**Re: Submission to the Proposed Macdonaldtown Gasworks Remediation Project**

I refer to the Railcorp Macdonaldtown Gasworks Remediation Environmental Assessment for Exhibition, dated 24 April 2012, Volumes 1, 2, 3, 4 & 5 ("the Environmental Assessment").

Figure 2: Chullora Site Layout

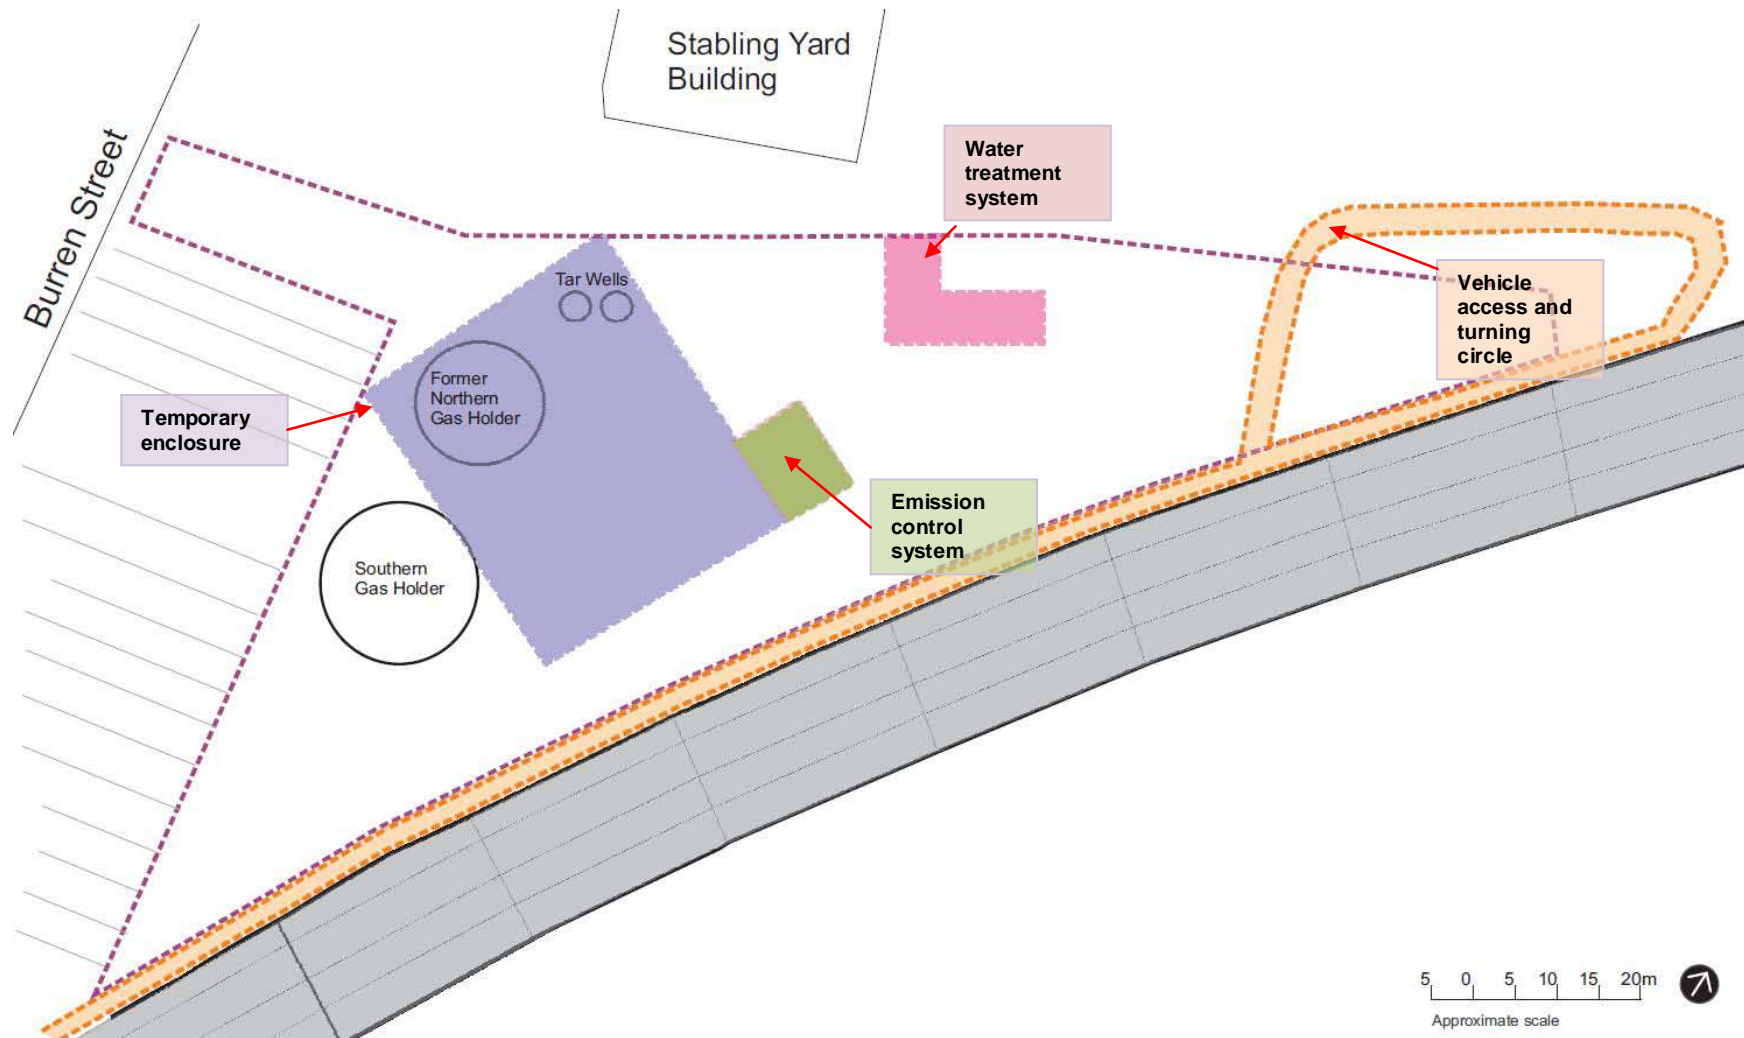
The Environmental Assessment has been reviewed, and Council's officers formed the view that the application not be supported. Council therefore objects to the proposal. Council is of the view that the stockpiling of excavated materials from Macdonaldtown on the Chullora site would contaminate land, groundwater, and surface water. The Chullora site is also very close to the Cooks River Canal. The stockpiles would contain coal tar (and associated chemicals such as benzene and xylene) and would be stored on the grassed site prior to processing within the enclosed plant room on site.

It is proposed that 23,000m<sup>3</sup> of excavated material from Macdonaldtown would be remediated over a period of approximately two (2) years, part of which would be at Chullora, if required. Council has concerns that the amount of excavated material taken to Chullora may be significant at any one time, considering the large area allocated to storage on the map within the Environmental Assessment being over 1500m<sup>2</sup>. It is noted that for the purposes of odour, only 150m<sup>2</sup> of the outdoor stockpiling is permitted to remain uncovered. However, exposure to rain would mean the stockpiles would leach contaminants.

The Environmental Assessment shows that Chullora has only minor levels of contamination (typical of the industrial uses in the area) at present, and introducing coal tar and other contaminants to the land may result in remediation of that site, following completion of the proposed works. Also, it is unknown whether these stockpiles would be combustible.

In addition to the above, Council is concerned for the residents located some 150m to the east in Marlene Crescent and Davidson Street, in that they would receive offensive odours, both from the outdoor stockpiles and from the plant (should odour filters fail).
